TfNSW Reference: SYD17/00705/03

DPI&E Reference: SSI 8441

## **WARRAGAMBA DAM RAISING – EXHIBITION OF EIS - CREST ROAD, WARRAGAMBA**

### Environmental Impact Statement – Appendix O: Traffic and Transport.

Figure 24-22. Northern construction access route

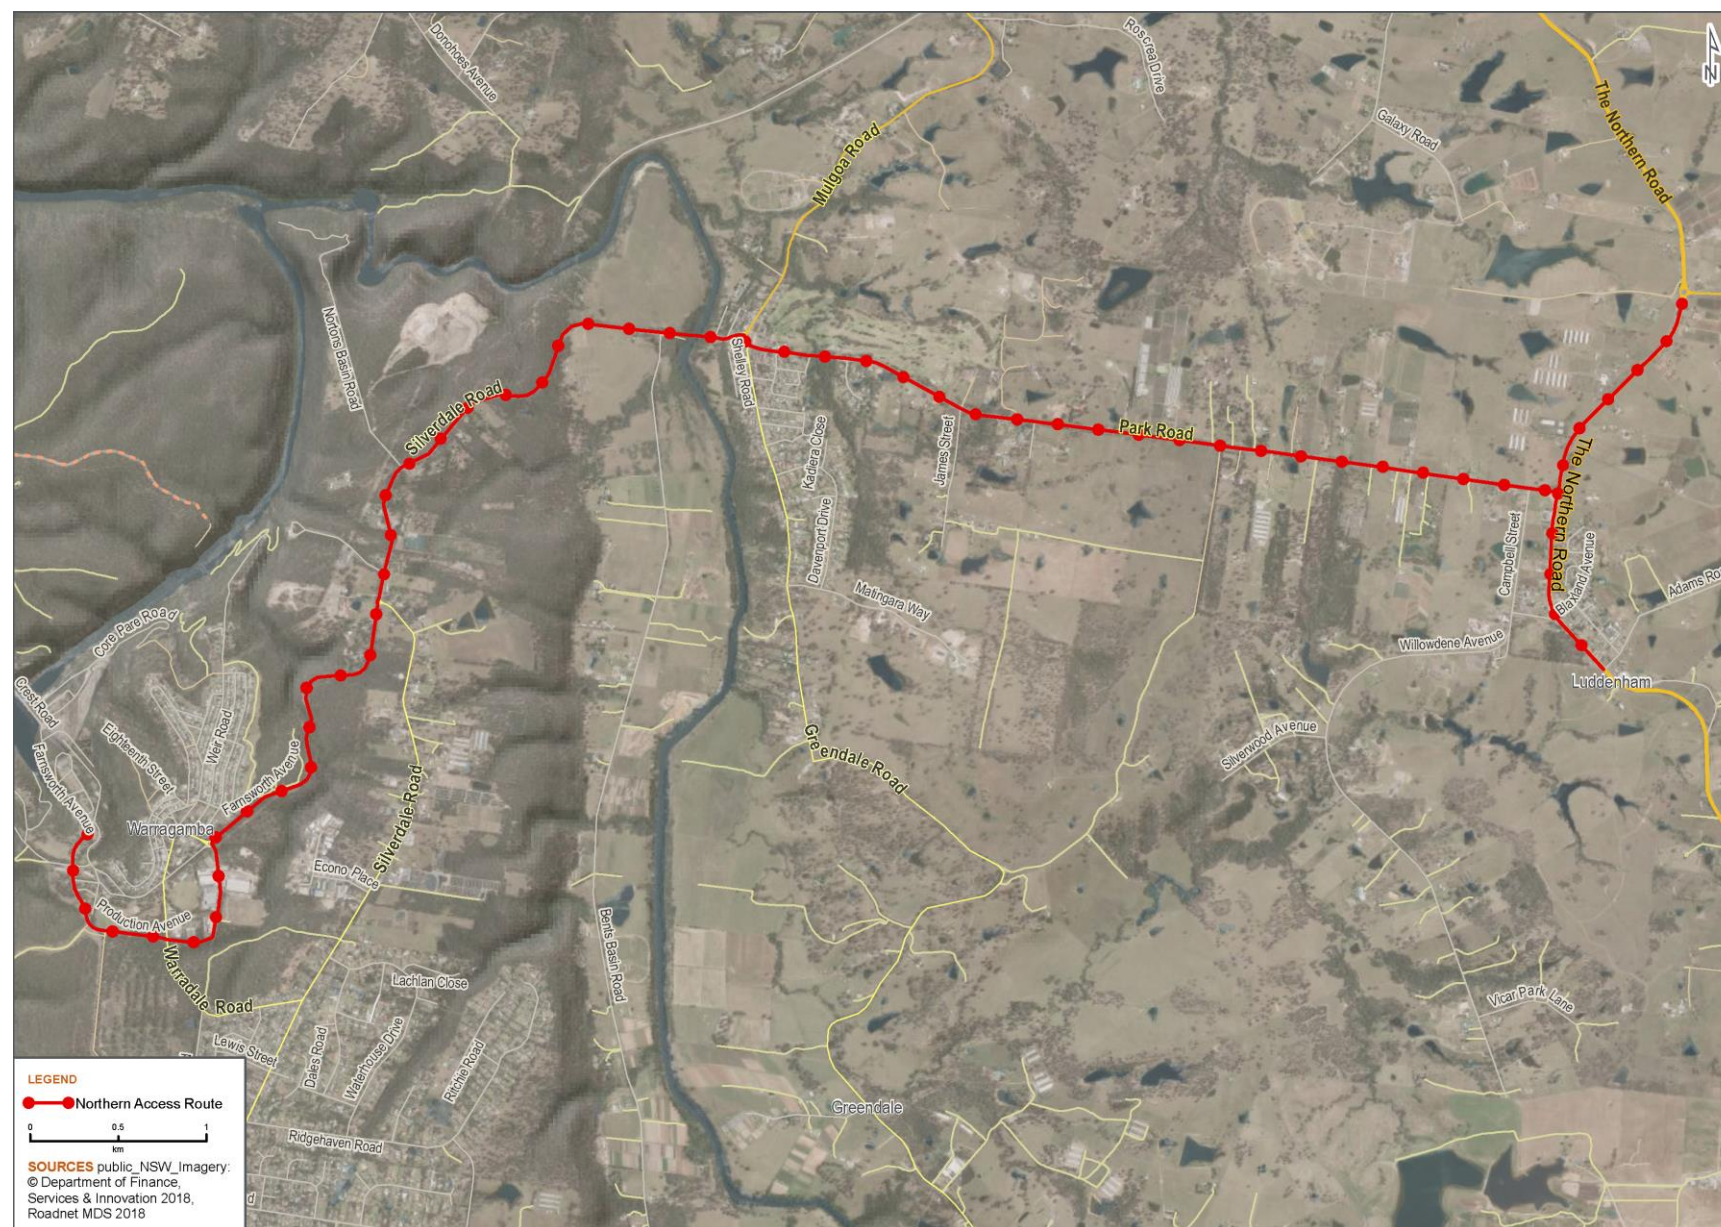
- a. The report does not provide information regarding Silverdale Road (unclassified regional road)'s current upgrade project nor accounts for its impact in this report.

Silverdale Road Safety upgrades Stage 2 (which covers the section of Silverdale Road used for construction vehicles movements by this proposal) has begun construction as of September 2021 and is expected to be completed in Q4 2022 therefore impacting the throughput and performance of the road at this section.

TfNSW requests the abovementioned information to be addressed/provided for further assessment prior to the determination of the application. TfNSW will further review and provide response upon receipt of the additional information.

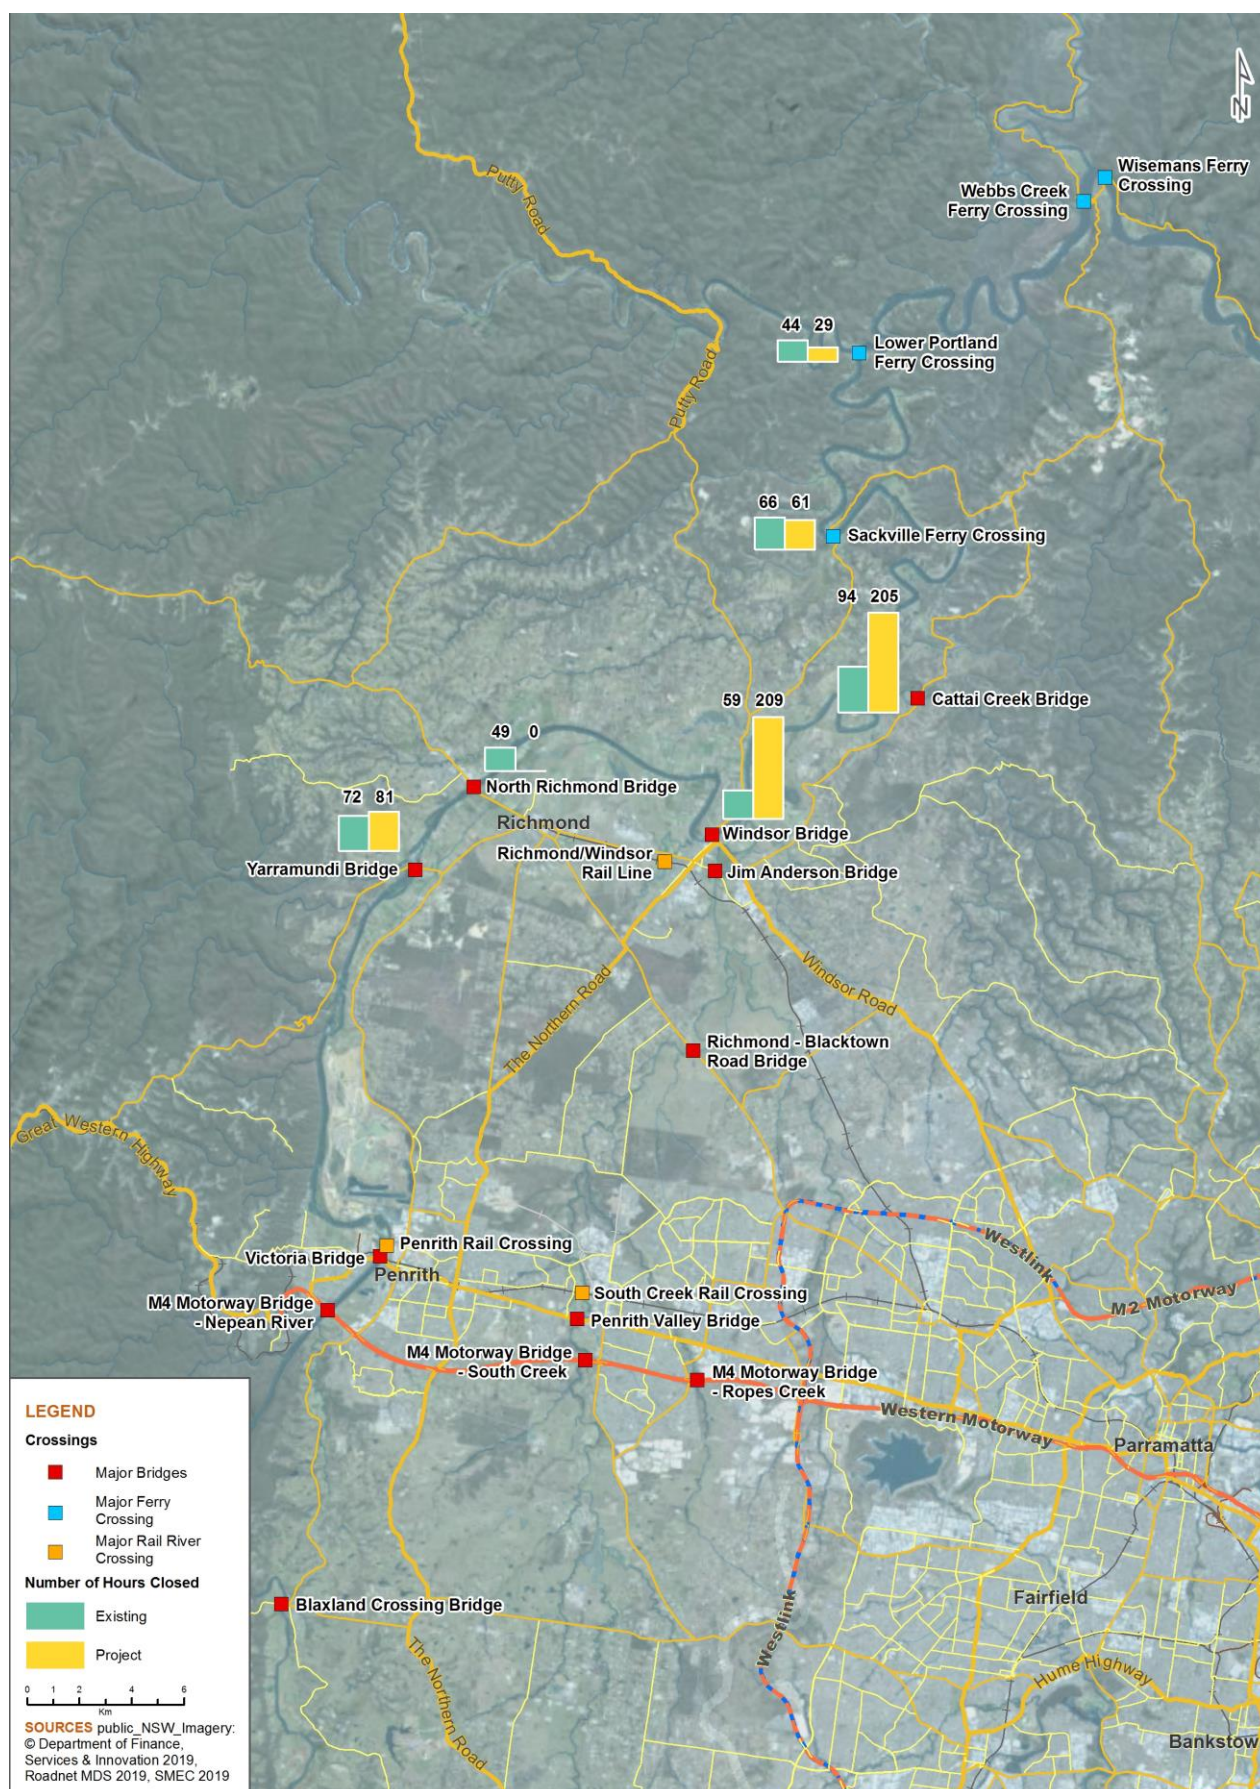
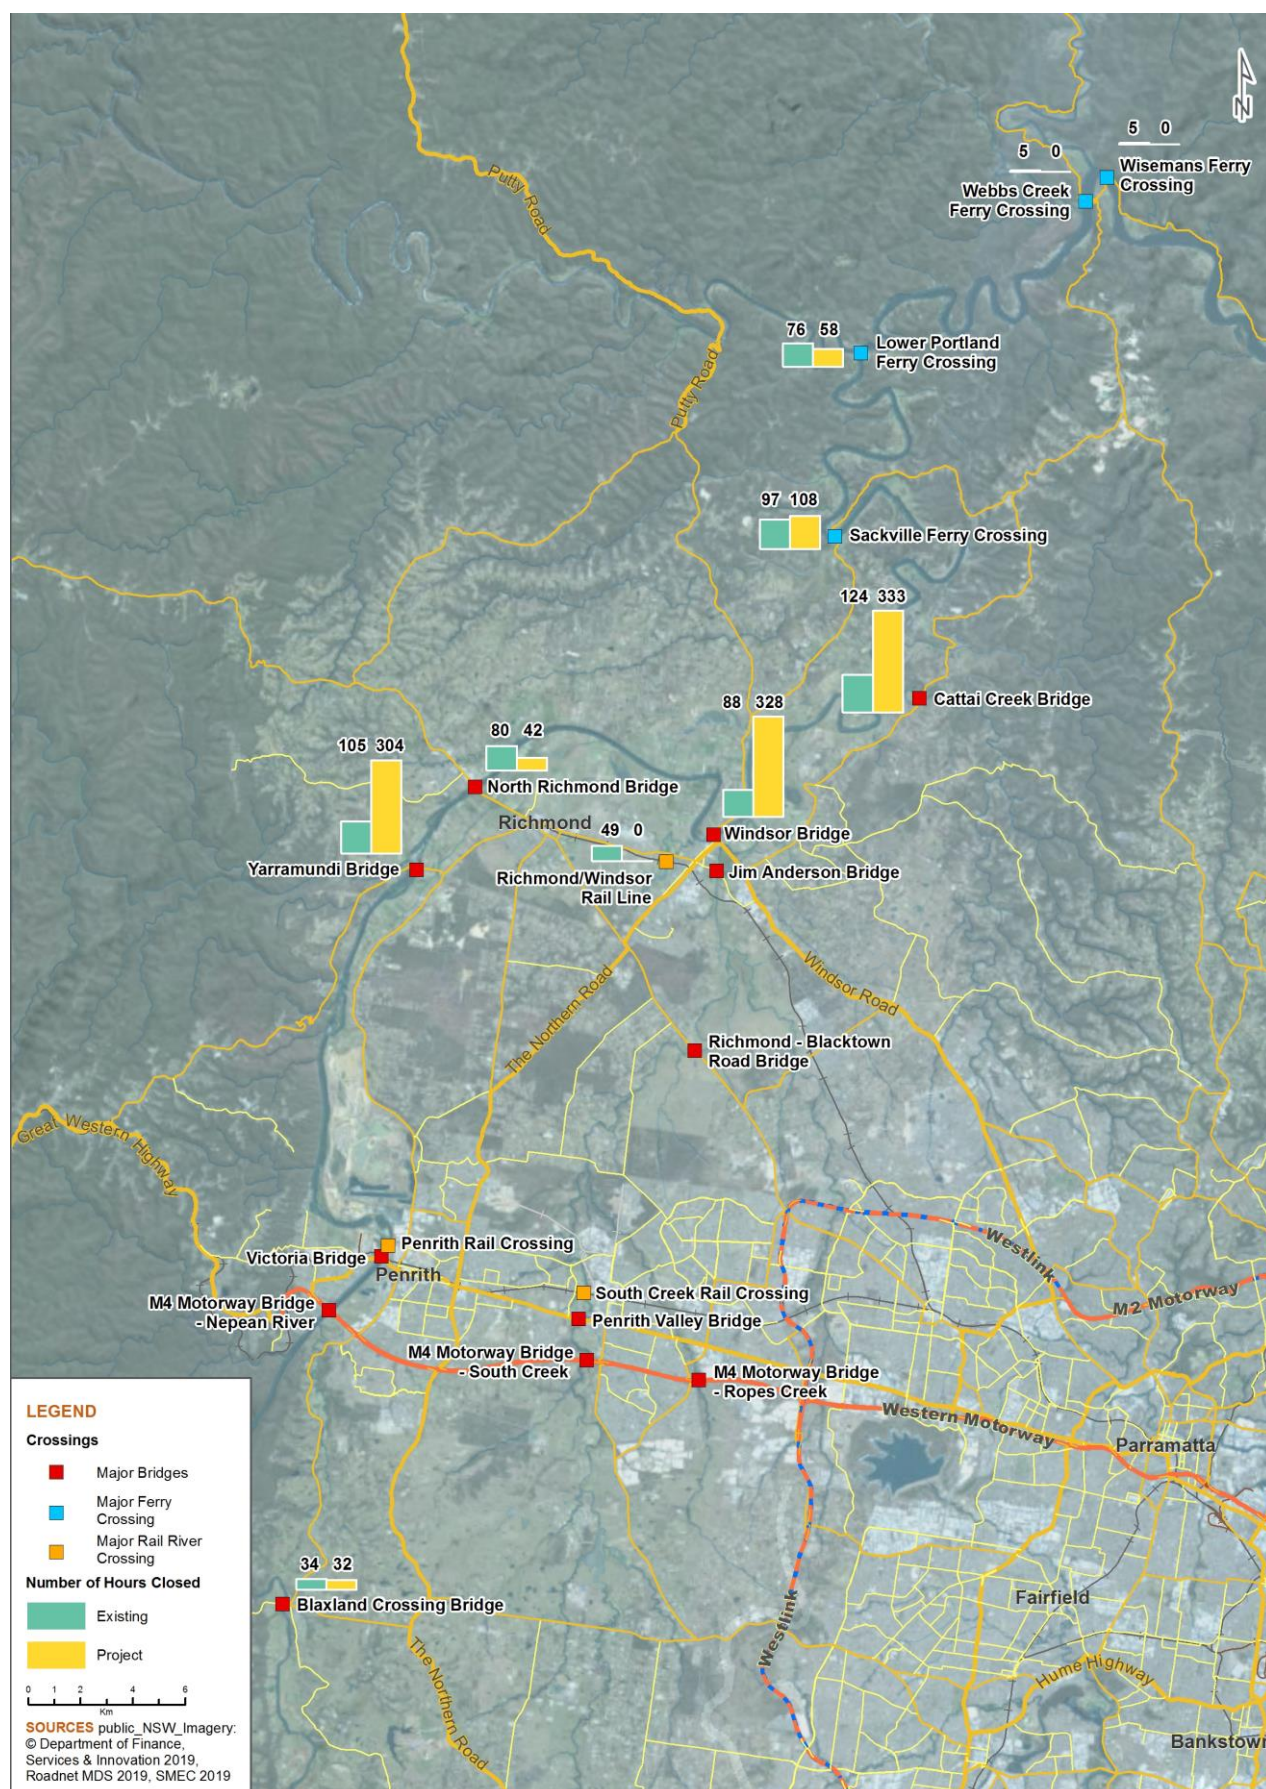
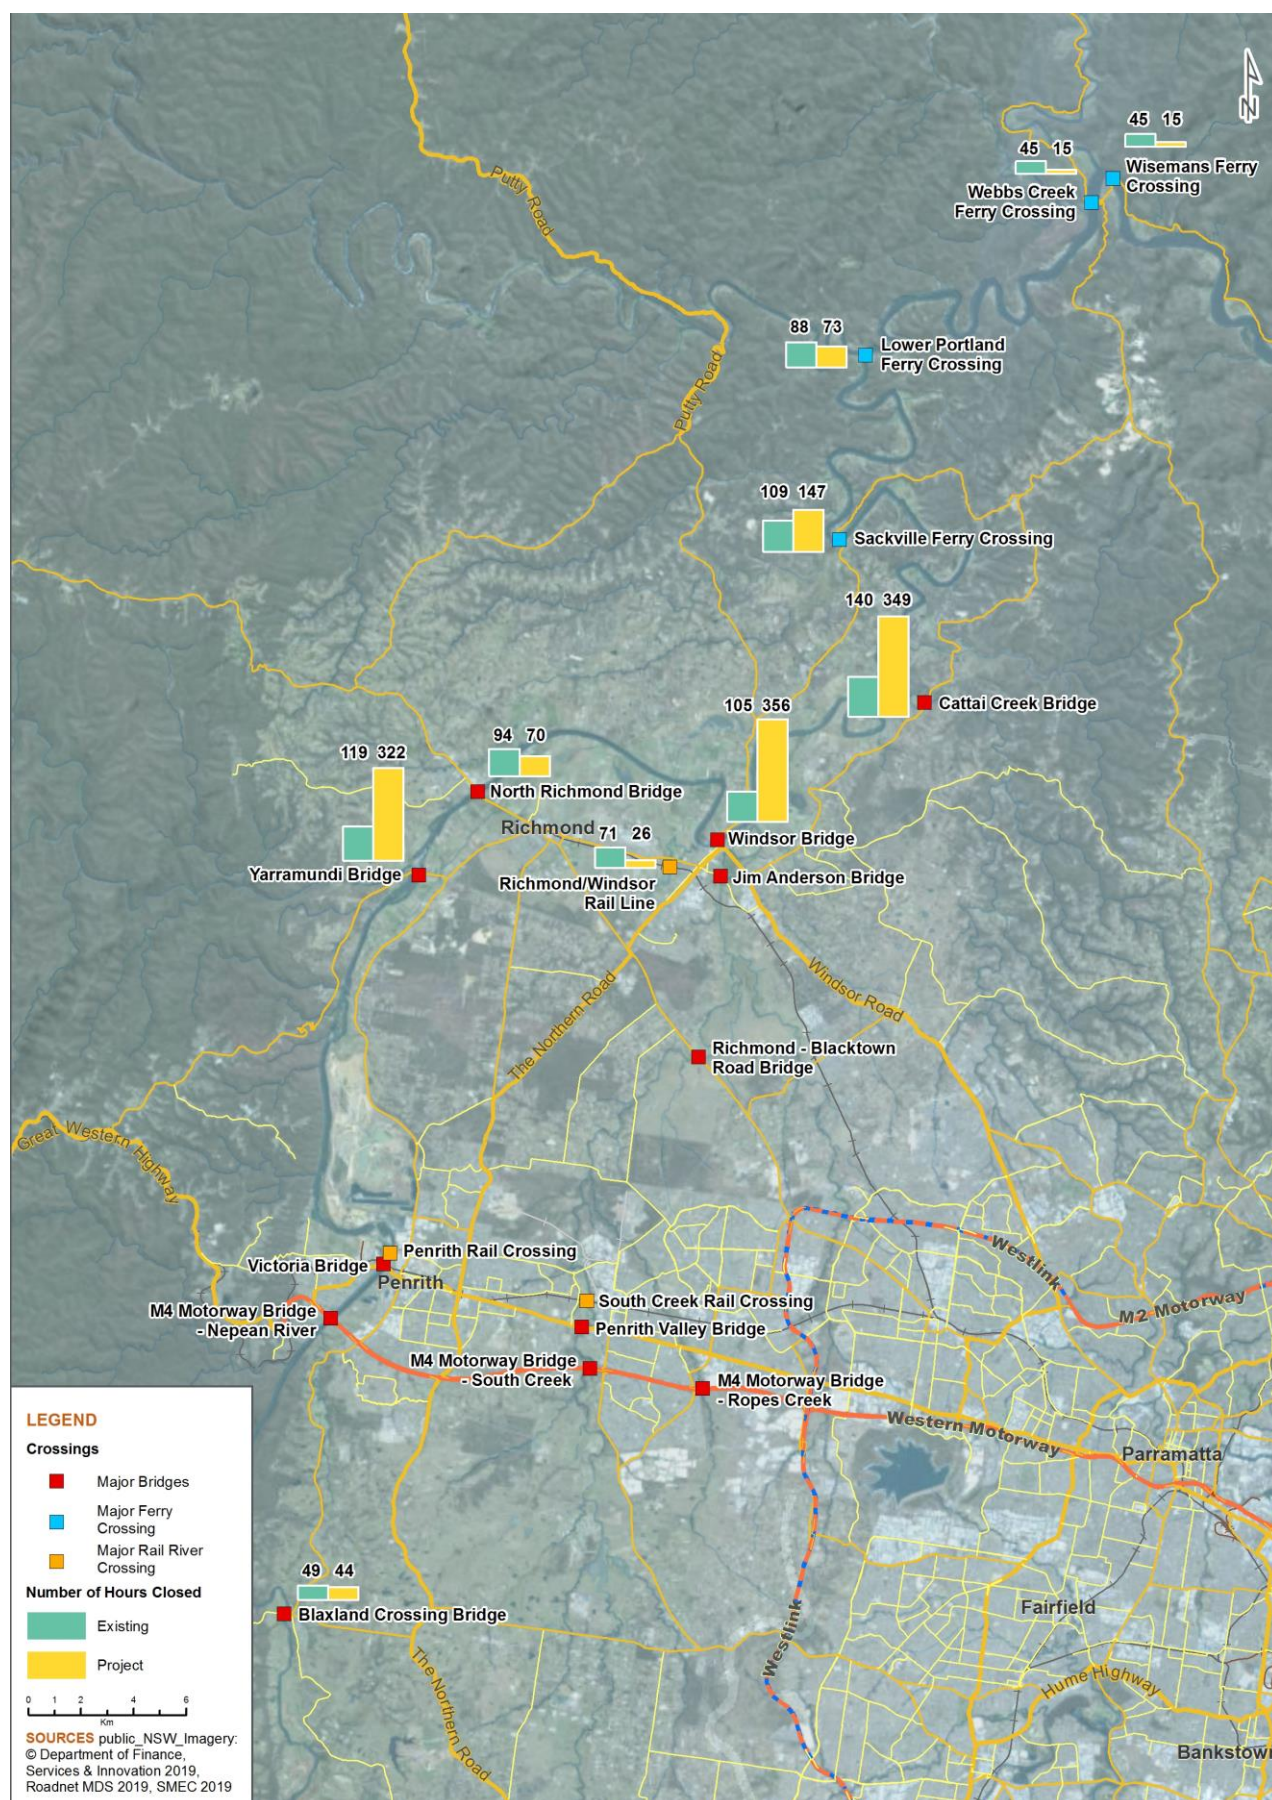
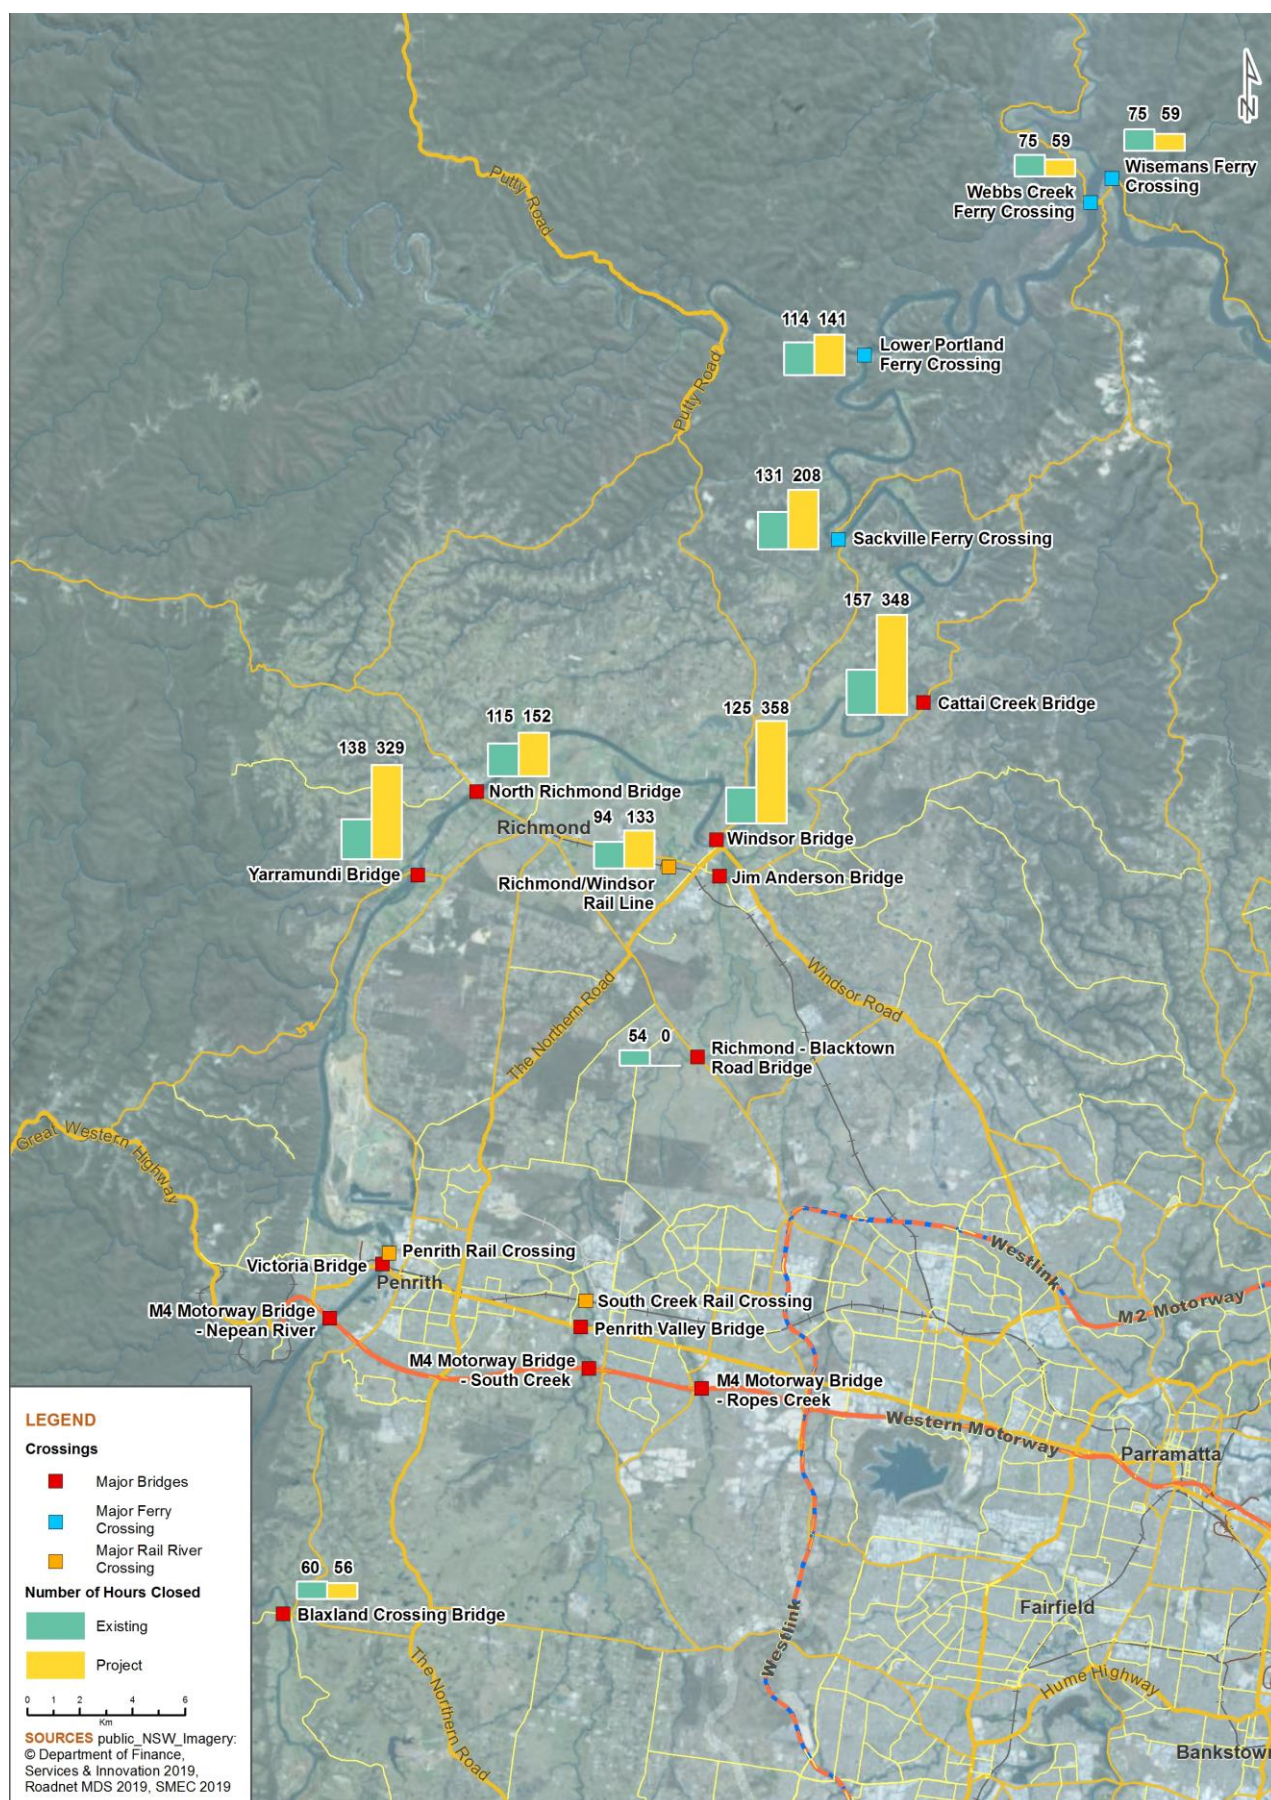
Section 5.2.2 discusses the project’s impact on major road river closure times due to flooding. The report indicates that four bridges are severely impacted by this project as shown in the excerpt below:

- i. Windsor Bridge (Bridge Street) forms part of the Wilberforce Road (state road 182) with an estimated traffic volume of 19,300 AADT in both directions.
- ii. Cattai Creek Bridge and Yarramundi Bridge are similarly part of state roads 181 and 570 respectively. Traffic volumes travelling along Springwood Road are estimated at 5,000 AADT.

It is noted that the only mitigation proposed as detour arrangements to mitigate these delays.

TfNSW would like to understand if there have been any other mitigation measure explored other than detour arrangements.
